28 April 2022
CG22/0043

RE: VEHICLE STRIKE, THE OLD SHIP INN, 2 VALLEY ROAD, CLACTON ON SEA, ESSEX CO15 4AR.

This document intends to itemise the structural damage to the building resulting from the vehicle strike, advise temporary propping to make the building safe in the short term and propose remedial works to reinstate the structure to a safe and stable condition.

Eng: SD Date: 4/22 Job No.: 222/043 Sheet TW/01 of 01

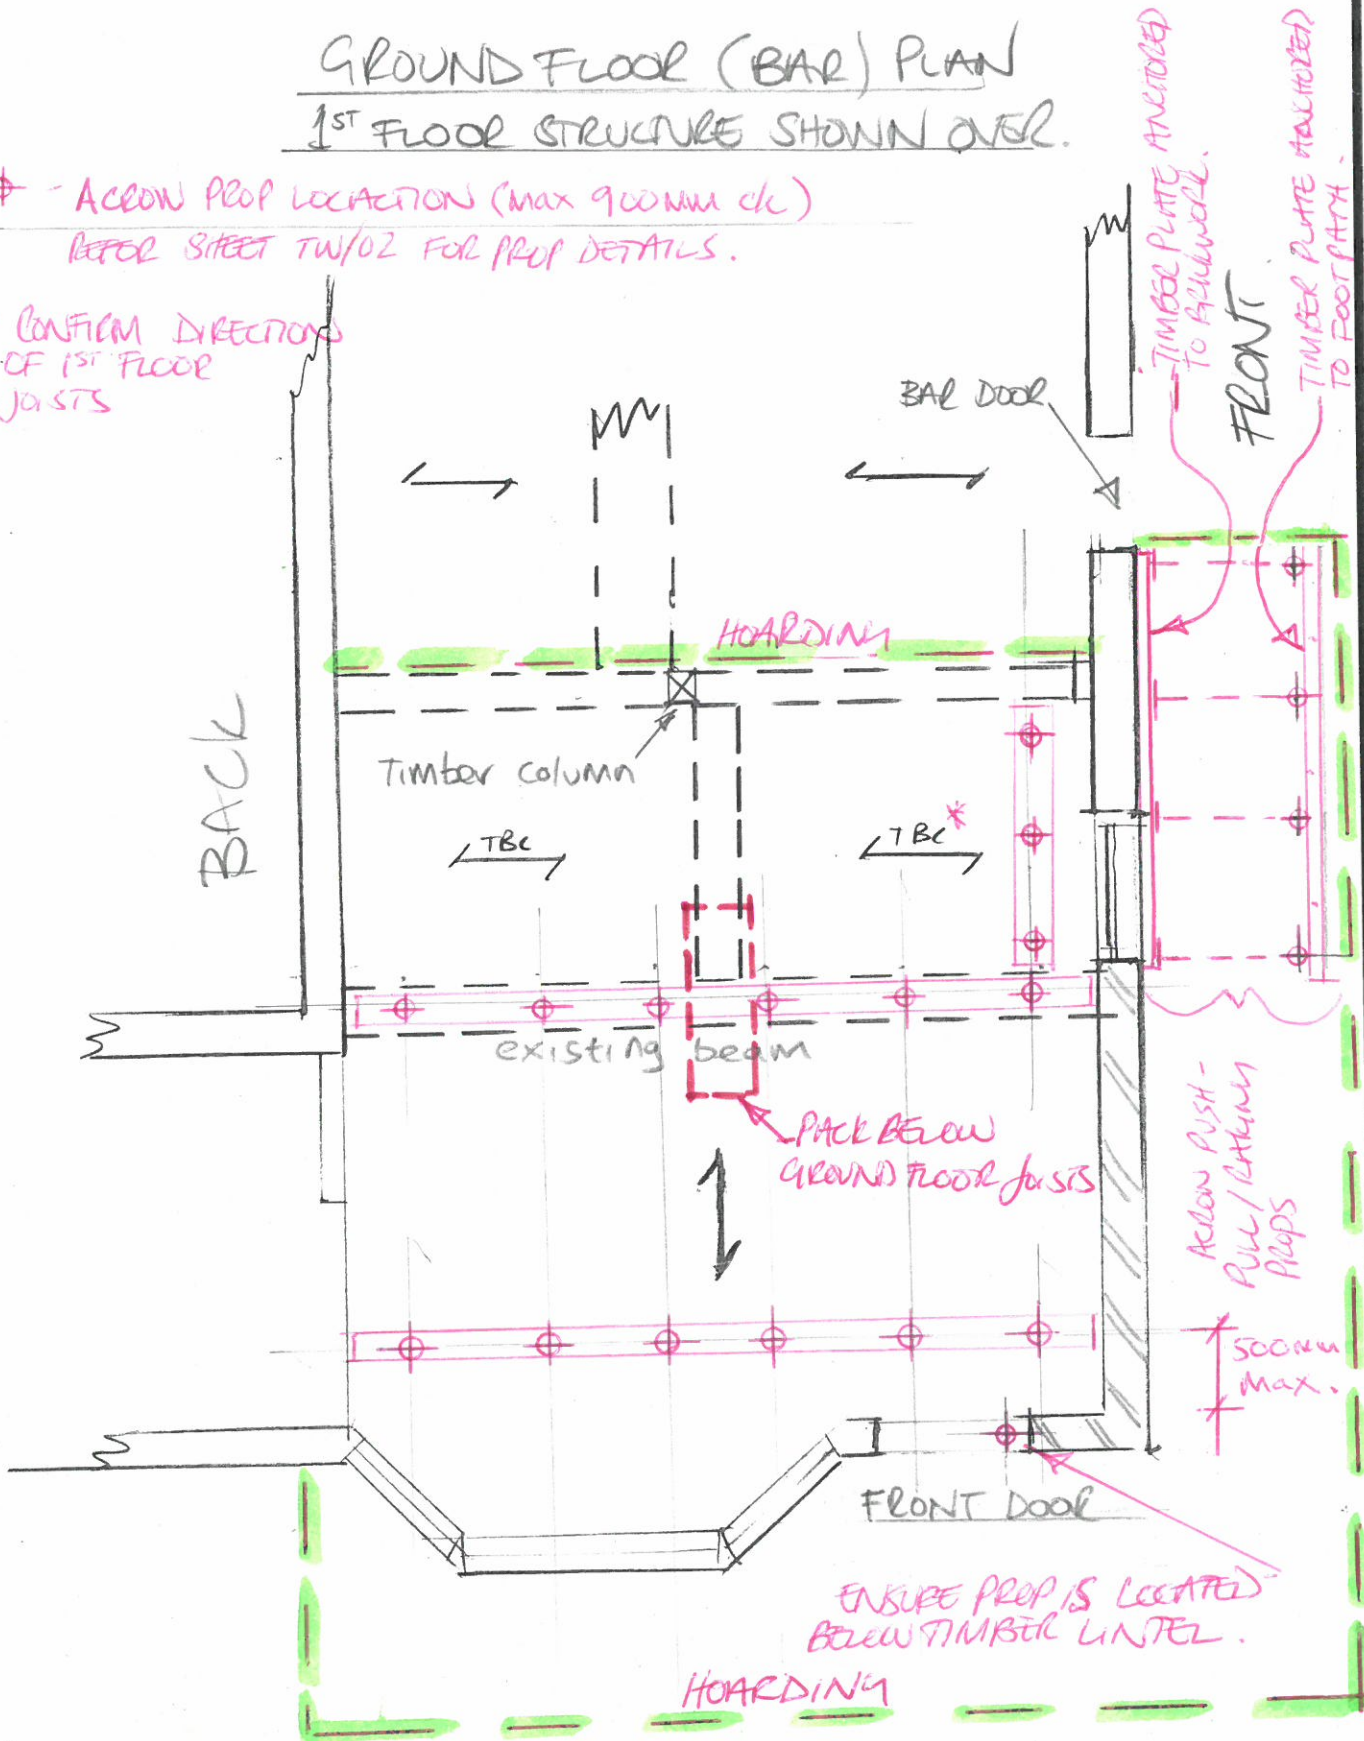
A temporary propping scheme was discussed and agreed with the contractor on site. Sketches TW01 & TW02 were produced to illustrate the propping requirements and provided to the contractor to be implemented. These sketches have been reproduced in Appendix B of this report.

- Install props as indicated on enclosed sketches TW01 & TW02. Pack below ground floor joists at mid span as shown on Sketch TW01.
- Remove external render and internal finishes and carefully take down external wall brickwork for extents shown on Photographs 1 & 2 in Appendix C of this report. If any purlins or beams not identified in this report are found to be bearing on this wall, stop work and identify JP Chick & Partners immediately.

Eng: SD Date: 27/4/22 Job No.: CC22/43 Sheet R.W./0.1 of 0.1

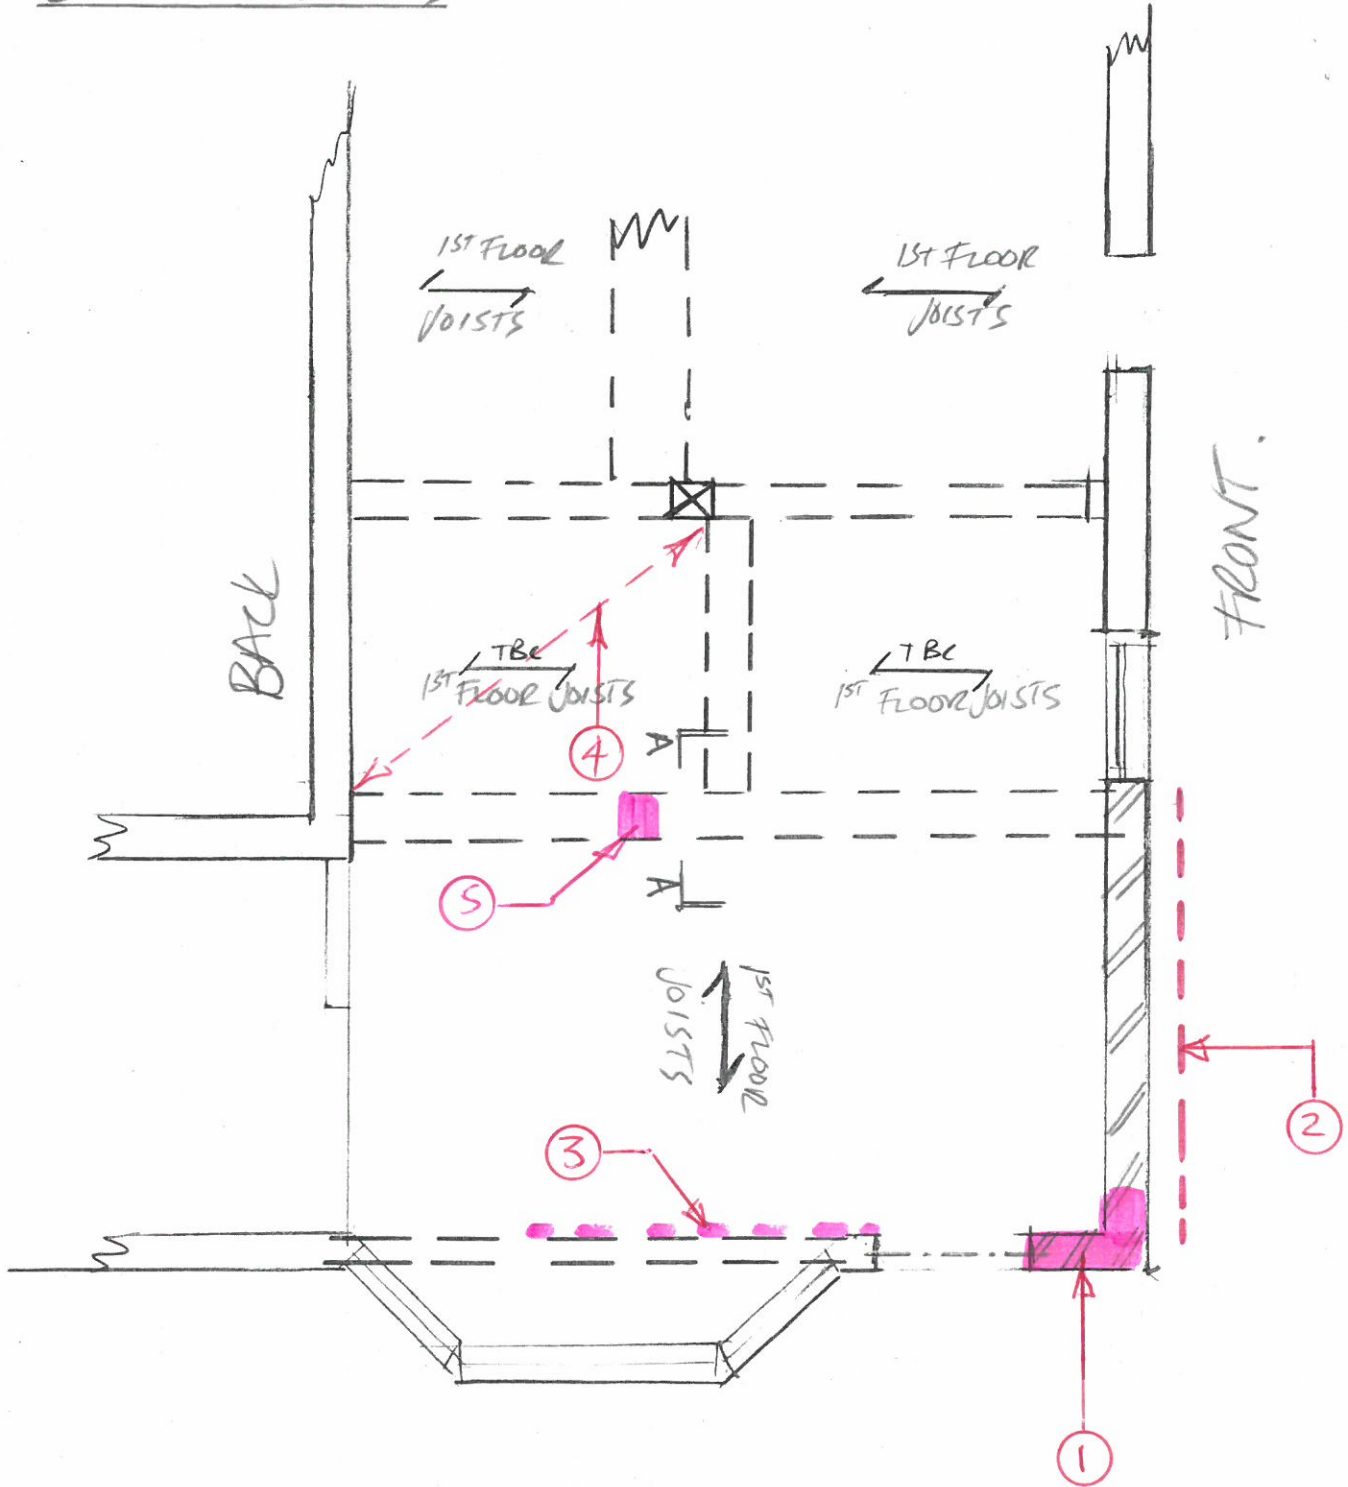
- The external wall panel at the point of impact has been destroyed between ground level and eaves level (Item 1), causing the timber lintel over the entrance door to lose its bearing.

- A horizontal crack in the brickwork continues around the front elevation (north) external wall approximately 1m above ground level (Item 2).
- 1st floor joists notched into the Oak beam over the bay window have been displaced and lost around 10mm of bearing (Item 3).
- An Oak beam supporting the 1st floor appeared excessively deflected. The plywood cladding around the beam was removed and the beam was found to have split through its full depth (Item 5). This beam also appears to have been subject to an historic woodworm infestation and has rotted. We do not consider that the split was caused by the vehicle impact, as historic dust and debris was found inside the split timber. This defect needs to be addressed and rectified as part of the remedial work, prior to this area being reopened to the public.
- A portion of the plasterboard ceiling appeared to be sagging excessively (Item 4).

Eng: SD Date: 27/04/22 Job No: 1522/043 Sheet RW/02 of 02

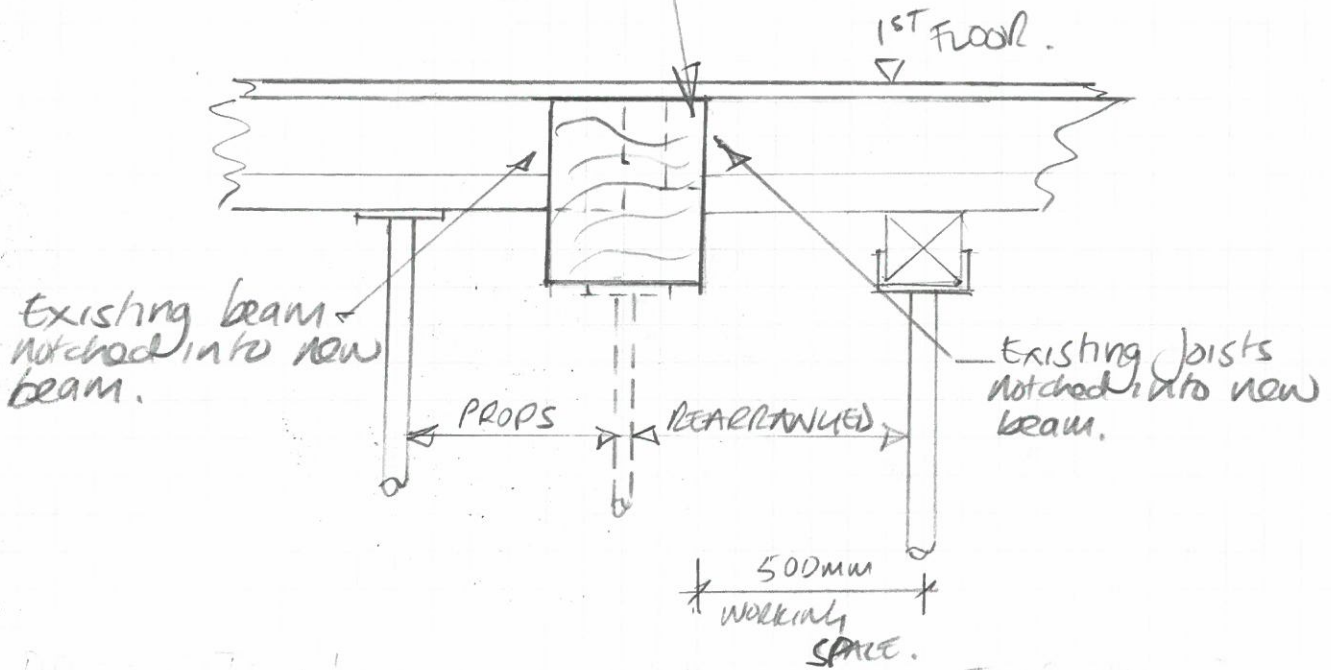
- Replace or repair the split Oak beam (Item 5) as shown on the enclosed sketch RW02, subject to approval by English Heritage.
We have provided two options for consideration.
 - A) Complete removal and replacement of the original beam with a new Oak section. We consider this the least intrusive option, as no shortening of the existing 1st floor joists will be necessary. The propping arrangement will need to be reconfigured to allow removal of the existing Oak beam. See Sketch RW02 in Appendix C.
 - B) The most desirable and unintrusive option would be to repair the existing oak beam, however given its current condition, we do not believe this is likely to be possible. A historic timber repair specialist could be commissioned to inspect the beam and advise whether it could be repaired. Contact JP Chick & Partners if required and we will advise a suitable specialist.

PHOTOGRAPH 1

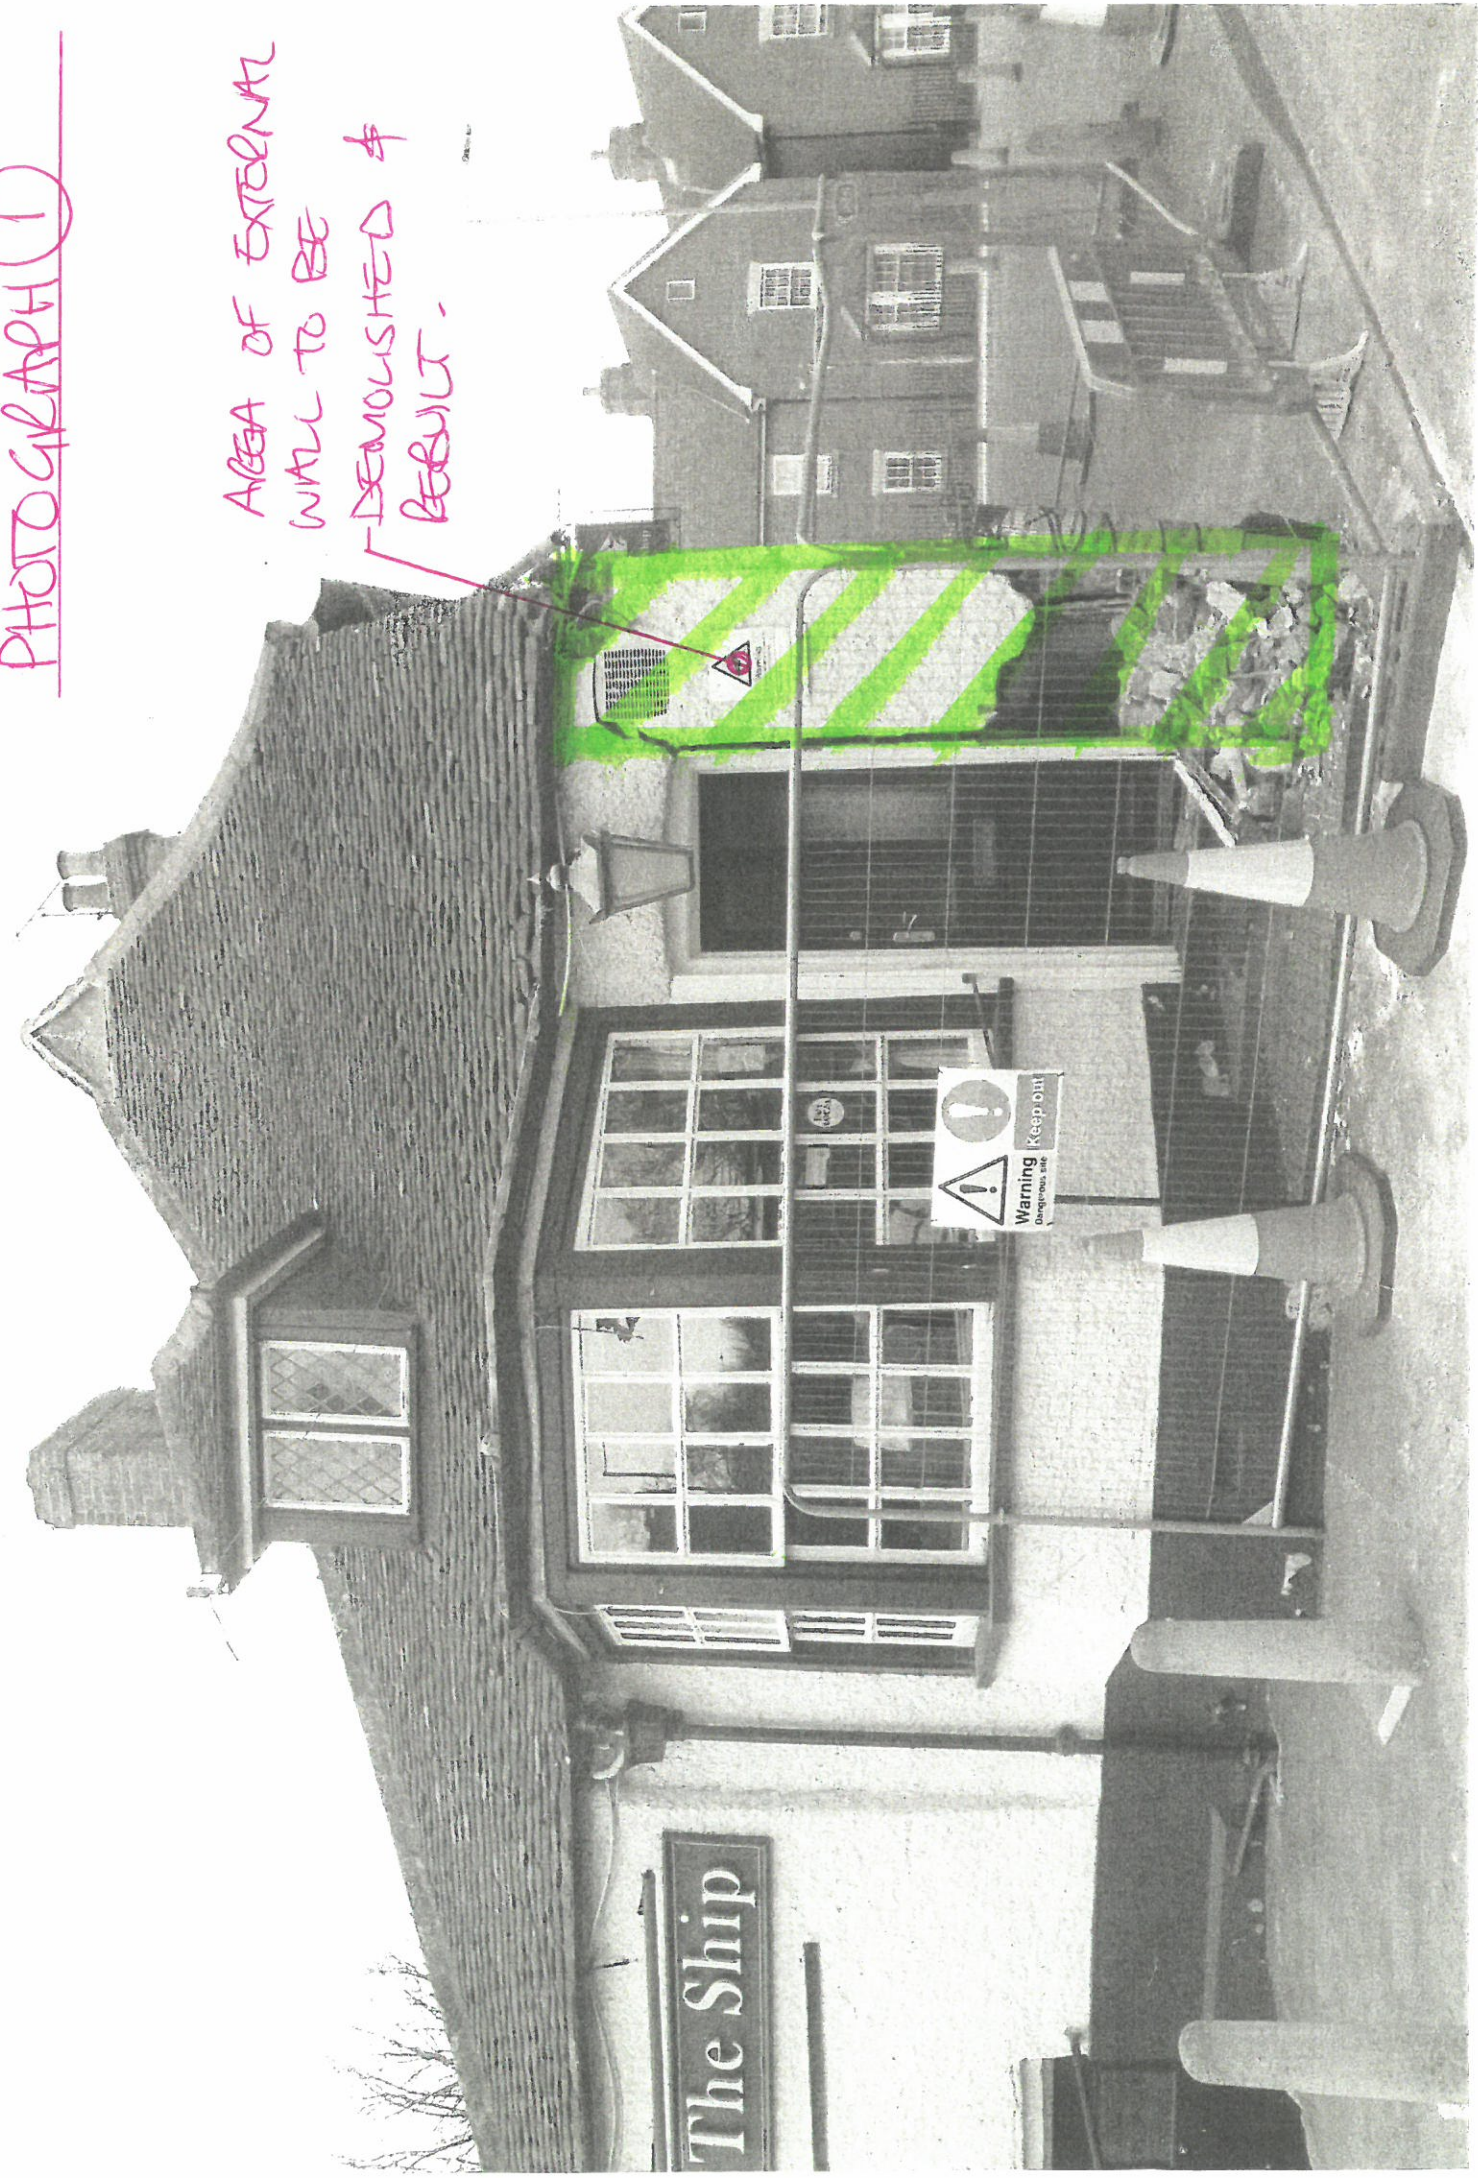
- Rebuild brickwork to reinstate the external wall. New brickwork is to be bonded into the existing. Brick units and bond are to match the existing arrangement. Any lintel and/or beam bearings must be rebuilt into the brickwork taking care to tightly pack any voids between the timber and brickwork with steel shims or well rammed dry pack. Any lintels damaged by the impact are to be identified to JP Chick & Partners for new lintel design.
